Our Ref: MIN2010/1

Section 75W Modification Application – MP09_0218 MOD 3 – Modification to the Dwelling Mix of Building A – 128 Herring Road, Macquarie Park

**Figure 4:** Floor Plan of the proposed one bedroom units with the studies indicated in red.

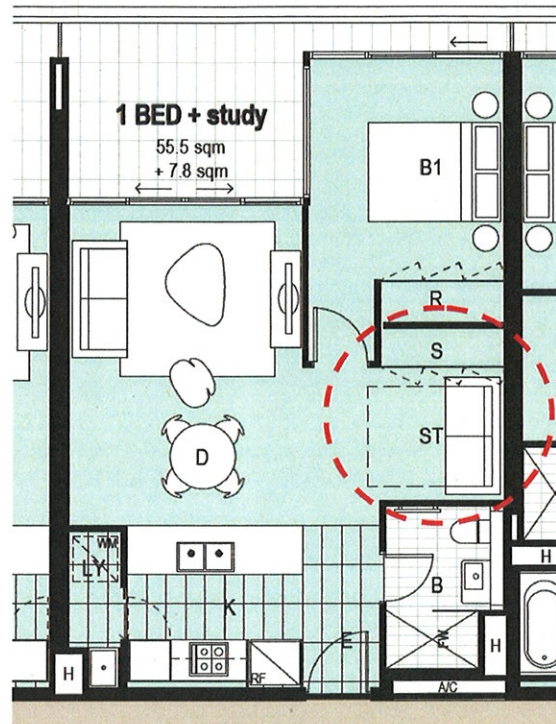
The proposed modification does nothing to alleviate Council's previously iterated concern that the large studies are capable of being used as bedrooms. In its previous determinations for this development, the Department has chosen not to require payment of a Section 94 contribution for these convertible rooms, against Council's recommendation. Council therefore makes no further submission on this matter.
